6550 Chief Road Brewery, PPR-22-47

Please accept the following comments from El Paso County Public Health for the variance request referenced above:

Site Development Plan

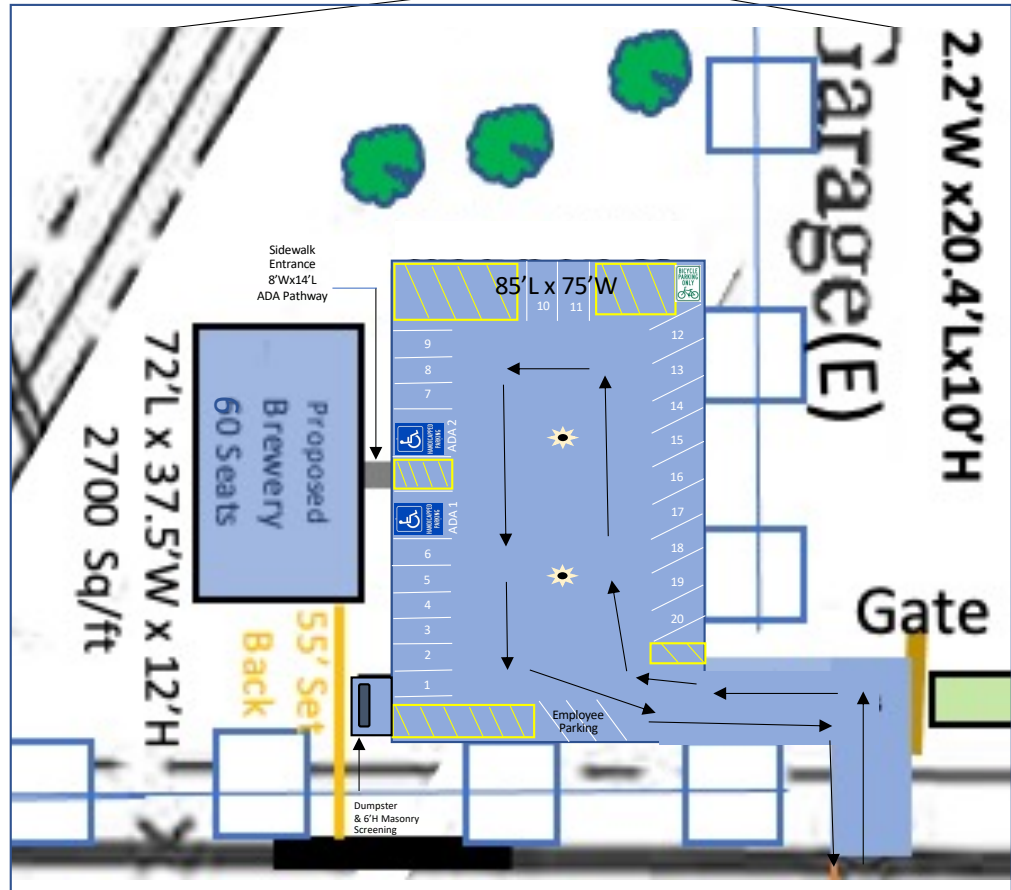
- **Parking areas and driveways must be located away from the soil treatment areas of the existing OWTS serving the residence, and the new proposed soil treatment area for the brewery.**
